Rezoning Transportation Analysis
Petition Number: Insert Zoning Petition #2021-060
General Location Identifier: 09509220

Revision Log:	Date	Description
	05-27-2021	First Review (WB)

Transportation Summary

**RZ-1.0**

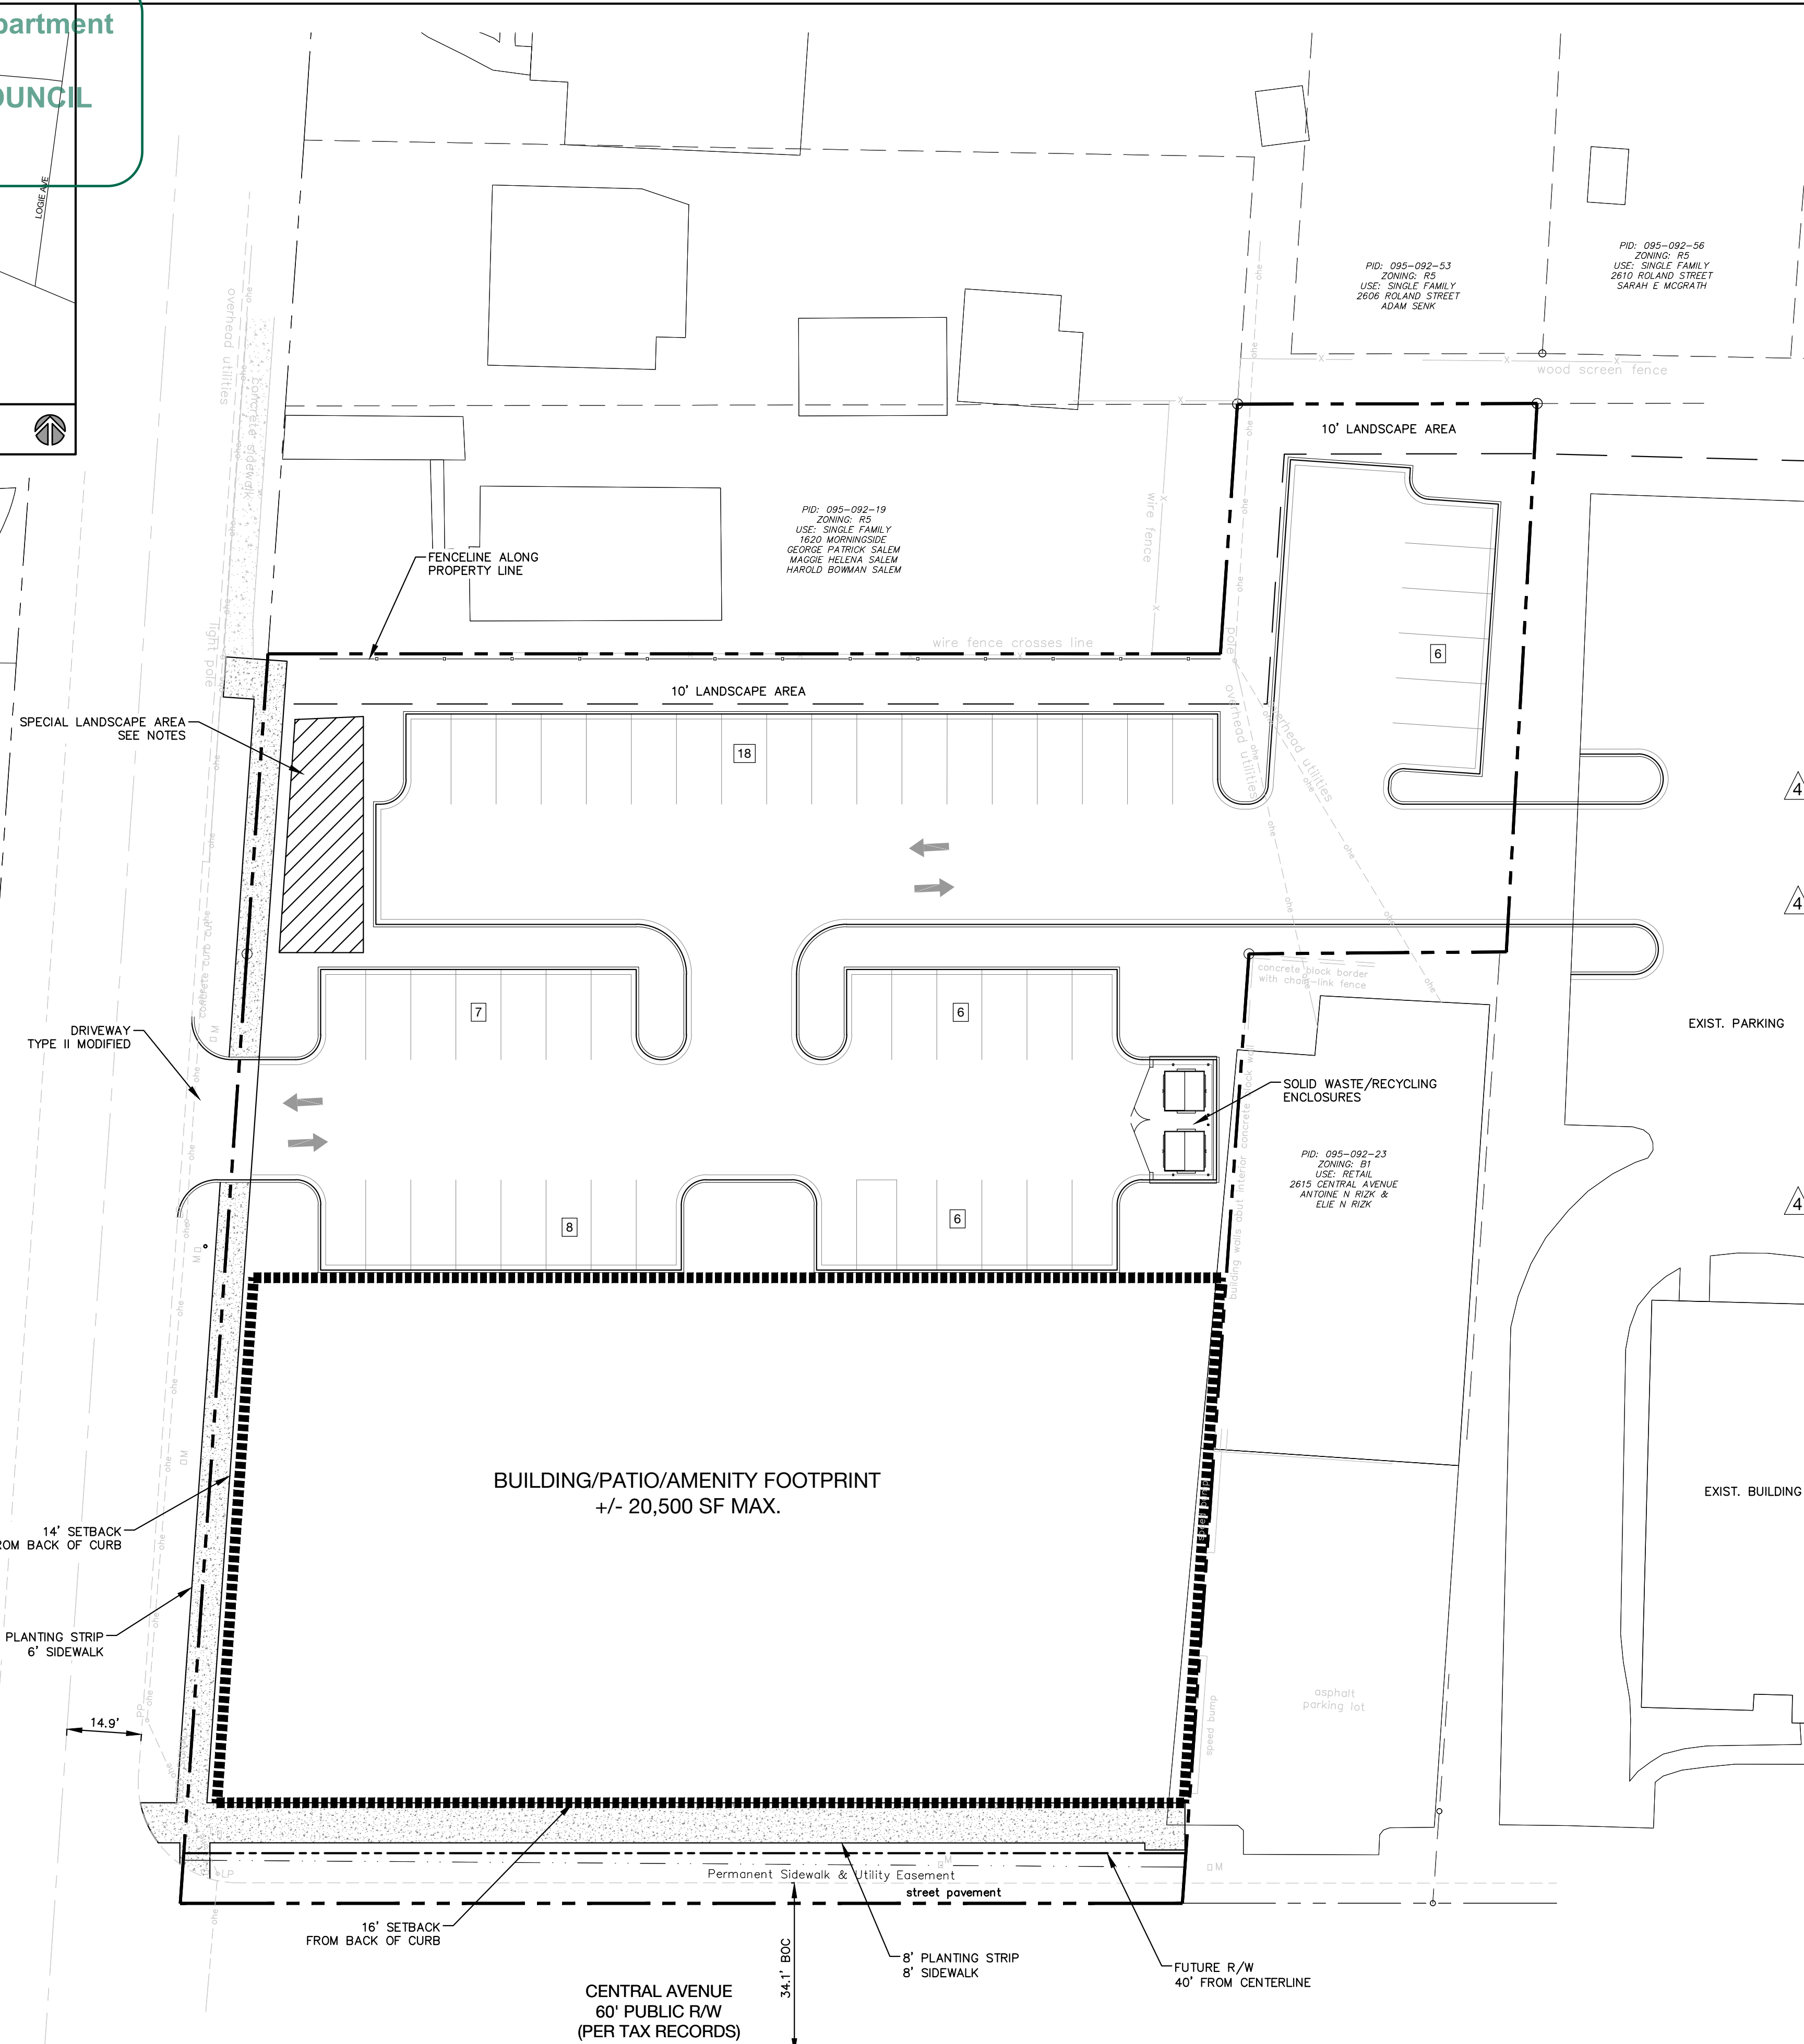
1. **Curbline:** The proposed zoning district has a setback measured from back of the existing or proposed future curbline.
 - a. **Central Avenue:** The future location of curb and gutter is in its existing location.
 - b. **Morningside Drive:** The future location of curb and gutter is in its existing location.

Label and dimension the curb and gutter from the centerline for each road on the site plan.

3. Site plan and conditional note(s) revisions are needed to install two curb ramps at the Central Avenue and Morningside Drive Intersection per ADA law and PROWAG standards.

4. Add a site plan note(s) specifying dedication and fee simple conveyance of all rights-of-way to the City before the site's first building certificate of occupancy is issued is needed. CDOT requests rights-of-way set at 2' behind back of sidewalk where feasible.
